Comments from Private Sector Housing:

17 NYEWOOD
GROUND FLOOR
1:50 SCALE

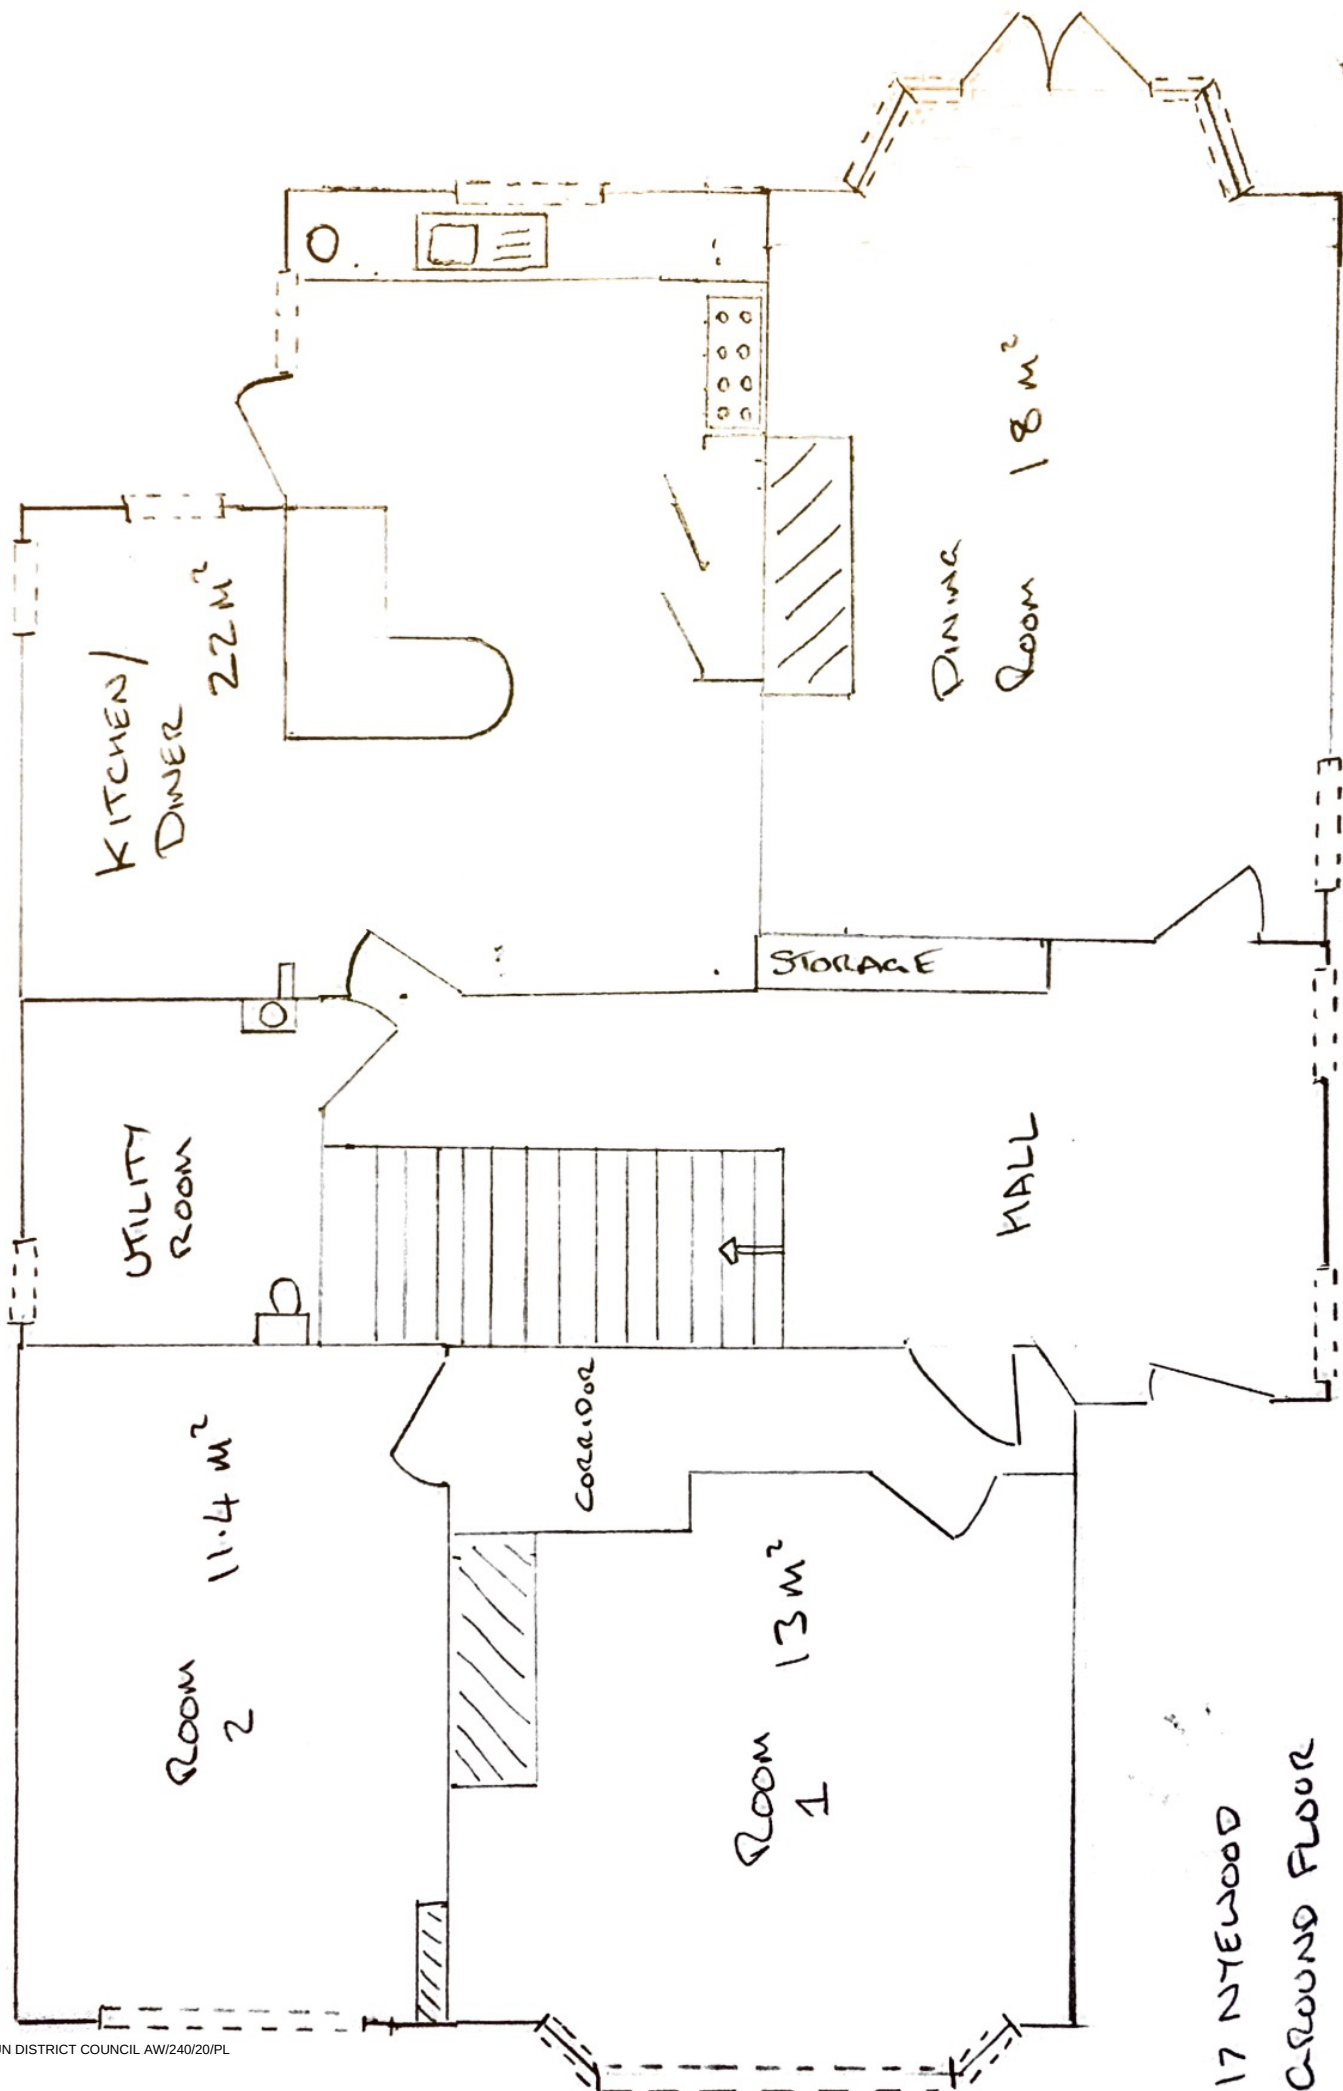
- A room where the only escape route is through another room is termed an “inner room” and poses a risk to its occupiers if a fire starts unnoticed in the outer room. In this application, the inner room is bedsit 7, with the outer room being the Sitting Room. For this to be acceptable, the following fire safety precautions must be implemented:

- Smoke detection, which is interlinked with the main fire alarm system and has an integral battery back-up, must be installed in both bedsit 7 and the Sitting Room.

- An FD30S fire door installed at the entrance to bedsit 7 (between Bedsit 7 and the Sitting Room) fitted with an overhead self-closing device, 3 fire-rated hinges, intumescent strips and cold smoke seals.

- The window in bedsit 7 must meet the requirements of an escape window, as detailed on page 16 of LACoRS fire safety guidance.
- A 30 min fire resisting escape route must be provided, which would include providing a 30 minute fire resisting and self-closing fire door (FD30S standard) to all risk room doors (bedsits, kitchen, sitting room and dining room).

- Final exit doors (kitchen, dining room and front door) must be fitted with emergency release mechanisms on the inside of each door, such as a thumb turn device, to enable a swift and safe exit without the use of a key, code or card.
